MEMORANDUM

DATE: October 27, 2023

SUBJECT: SF-22-035 – Sterling Ranch East Filing No. 1
Third Submittal

Engineering Division

STERLING RANCH EAST FILING NO. 1 UTILITY SERVICE PLAN			
DESIGNED BY	BB	SCALE	DATE 04/04/23
DRAWN BY	BB	(H) 1"= 50'	SHEET 15 OF 17
CHECKED BY	(V)	1"= N/A	JOB NO. 1183.30

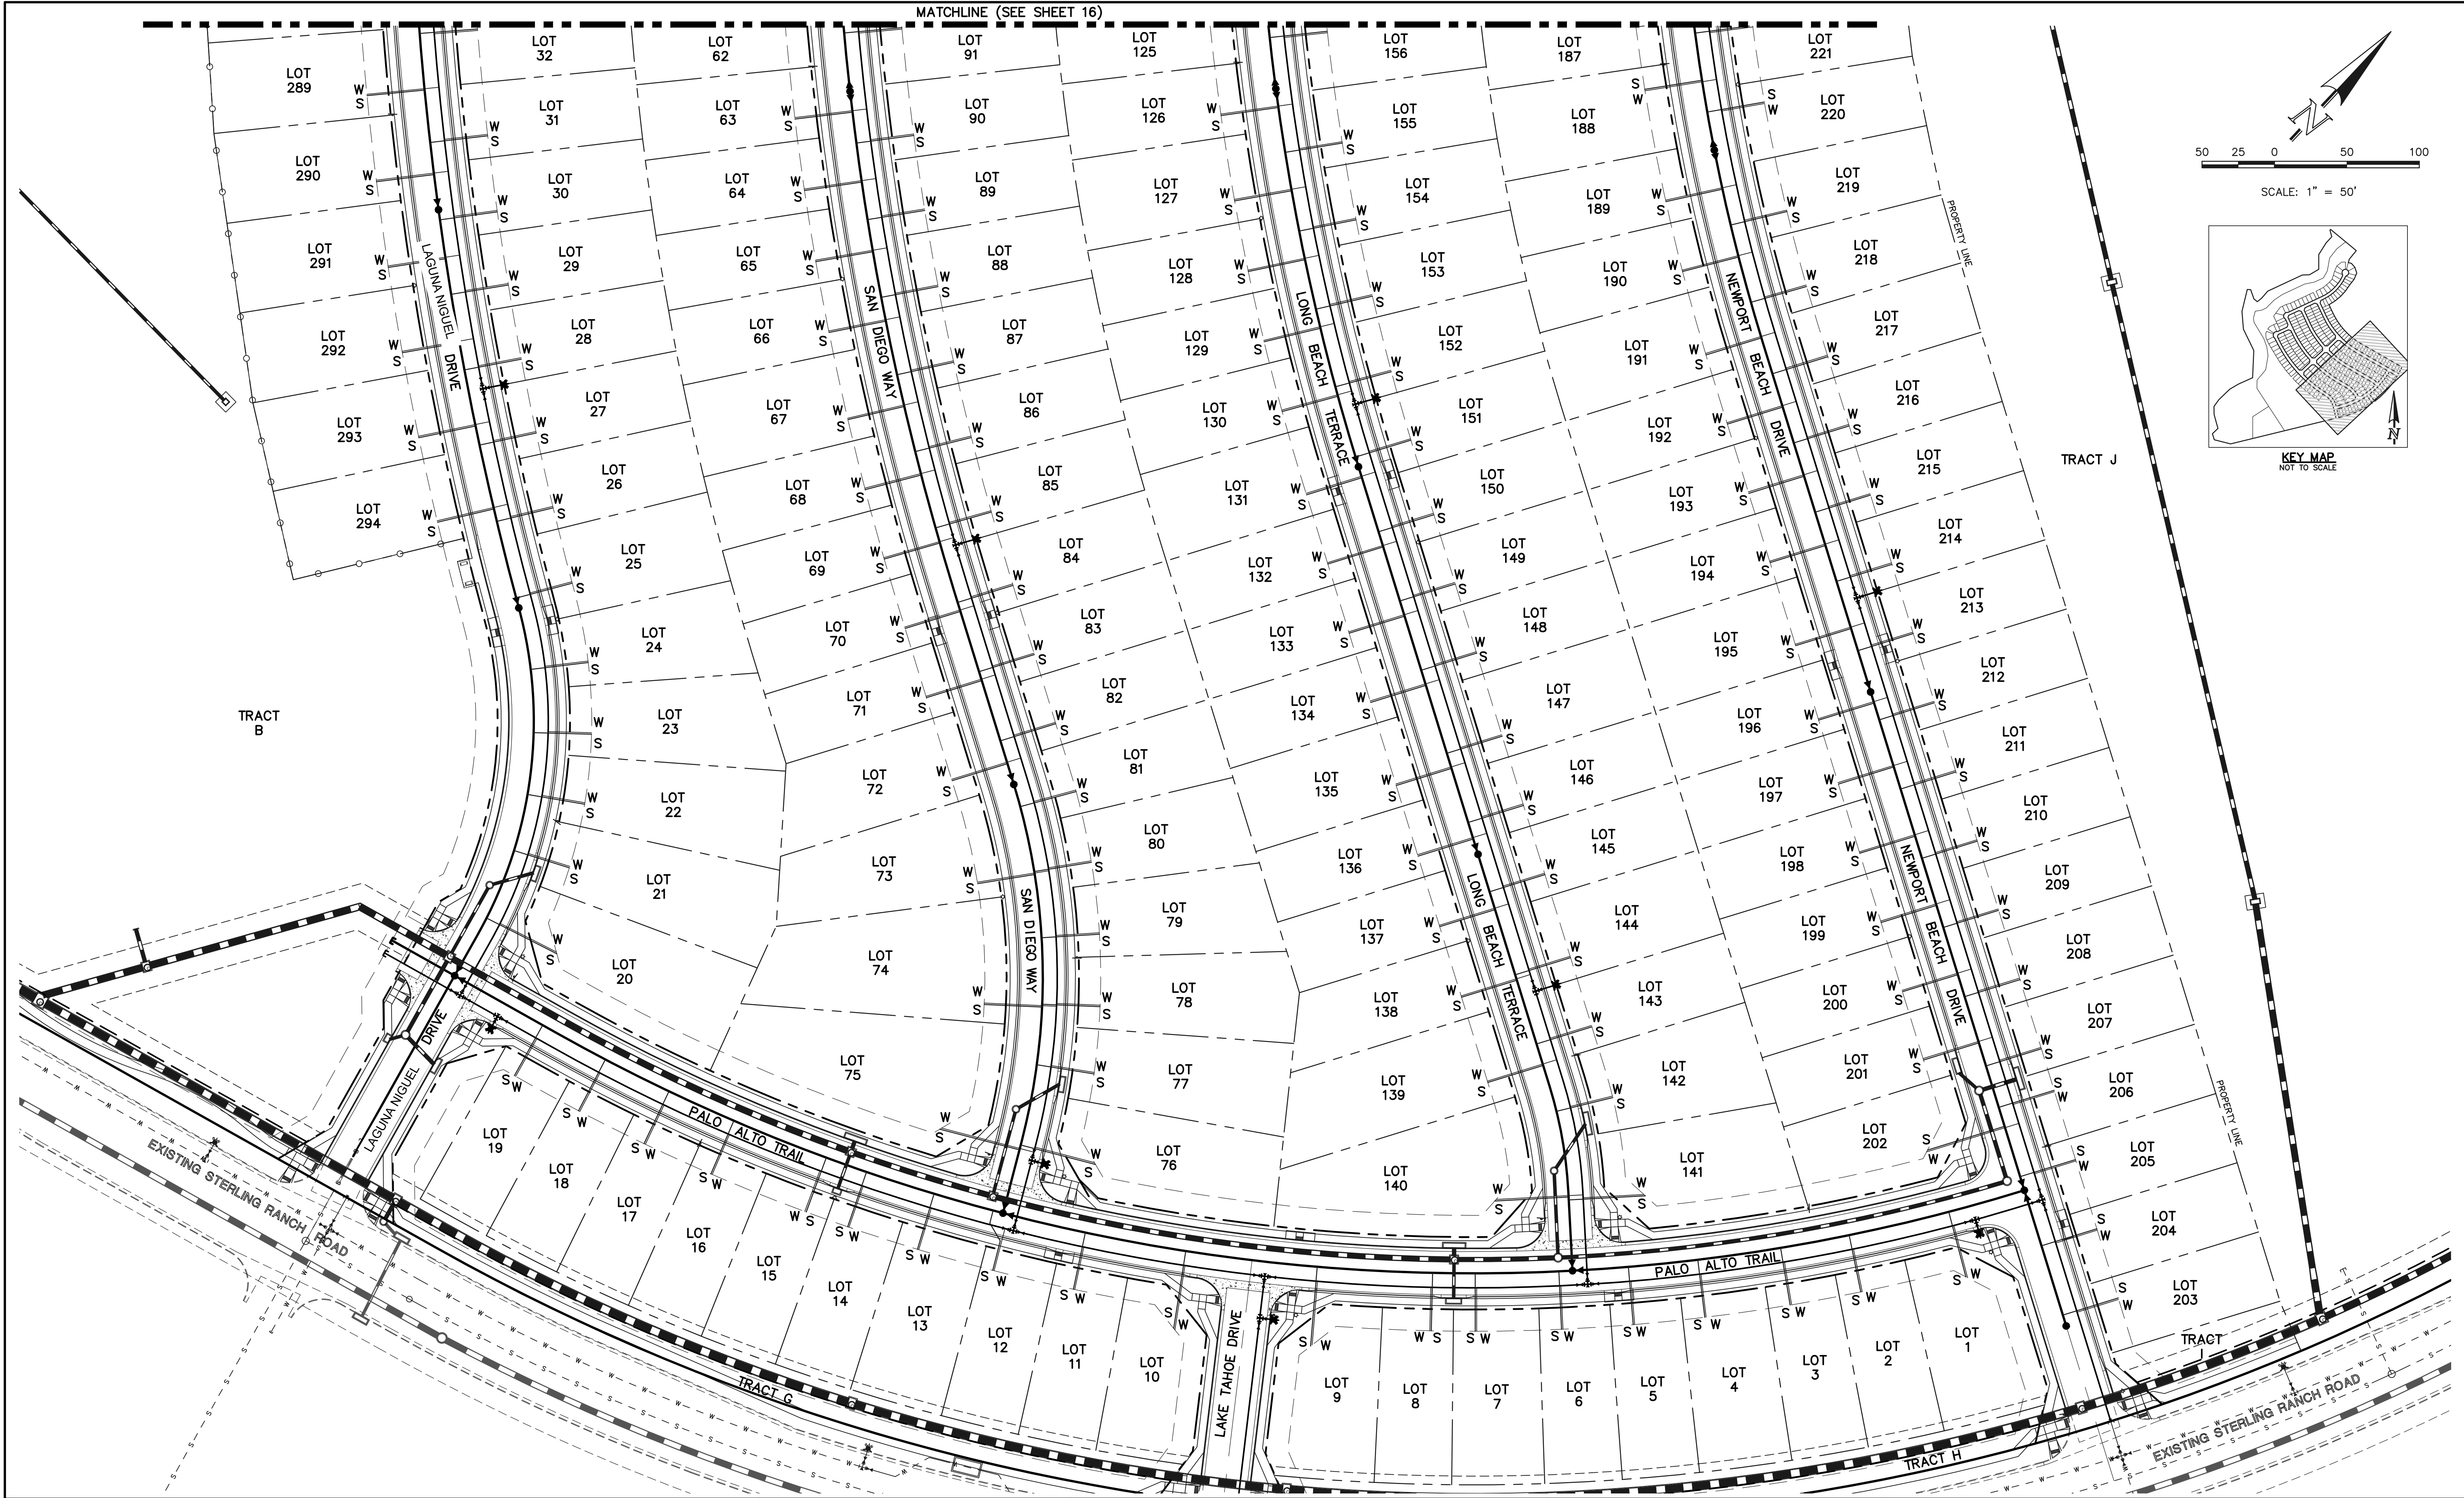
1. See CD/GEC redlines. **Resolved**
2. Provide the County CD signature block on the separate utility plans. Show the underdrain stub locations on the utility service locations details on sheet 17 and note and/or show the underdrain system outfall(s) on Sheet 2. **Unresolved.**
3. Pocatello Trail profile was adjusted on the CD's. Utility plans do not appear to have been updated with revised profile. Please update.
4. **Resolved.**
5. Provide the additional geotech studies referenced in the Soils and Geology report when available:
 - a. "It is anticipated that the shallow water areas will be mitigated with site grading and the installation of sewer underdrains. **Specific recommendations should be made after additional investigation and site grading has been completed.**"
